4th June 2021
Our Ref: D1922
ADC Ref: AL/27/21/PL

RE: AL/27/21/PL - FORMER GRAIN STORES, SACK LANE, LIDSEY

Thank you for passing on the comments from ADC with regard to the Flood Risk Assessment and Drainage Strategy submitted for the above planning application. Please find my response below.

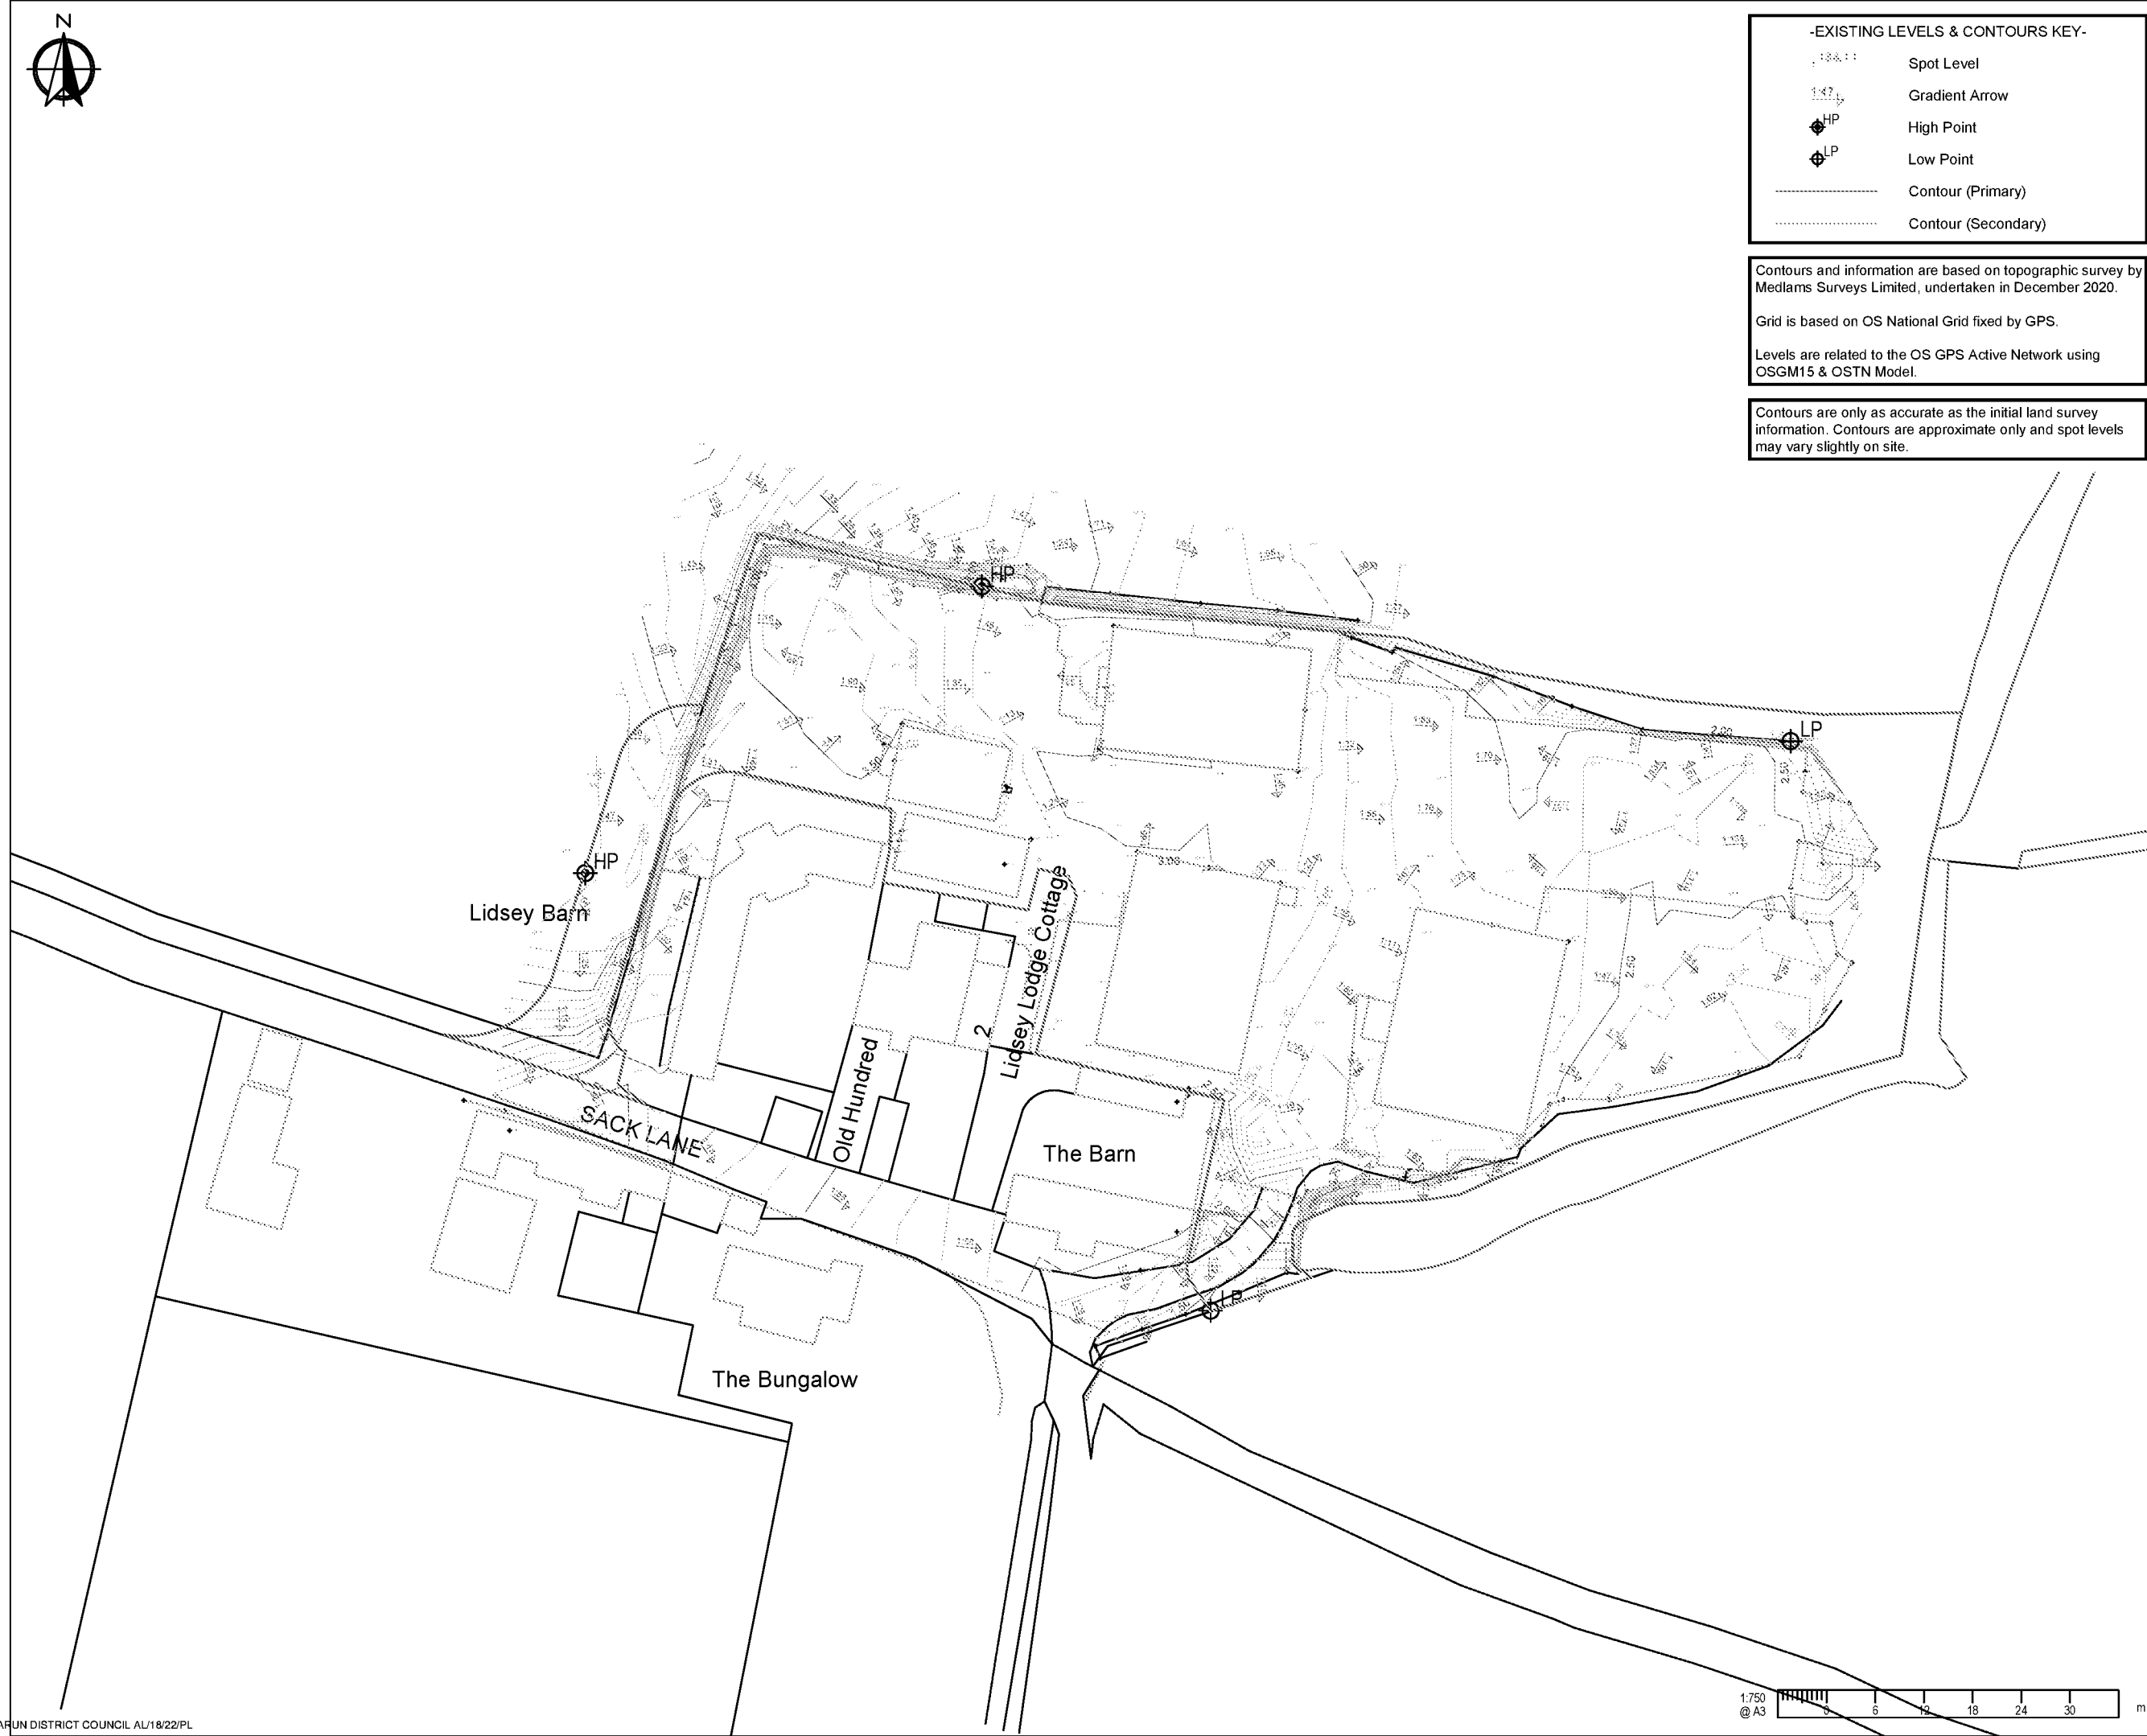
The applicants engineers are aware of the required easements to the watercourse as these are cited within the FRA. Please ensure that not only buildings, but also boundary fences are not sited within 3m of the watercourses. Please provide a plan showing the buffers and the flood zones if a future application is made.'

We are also agreeable that the maintenance buffer must be accounted for and have proposed a soft boundary feature in our revised Drawing D122-200 Rev A to allow for this. This will be addressed further at detailed design.
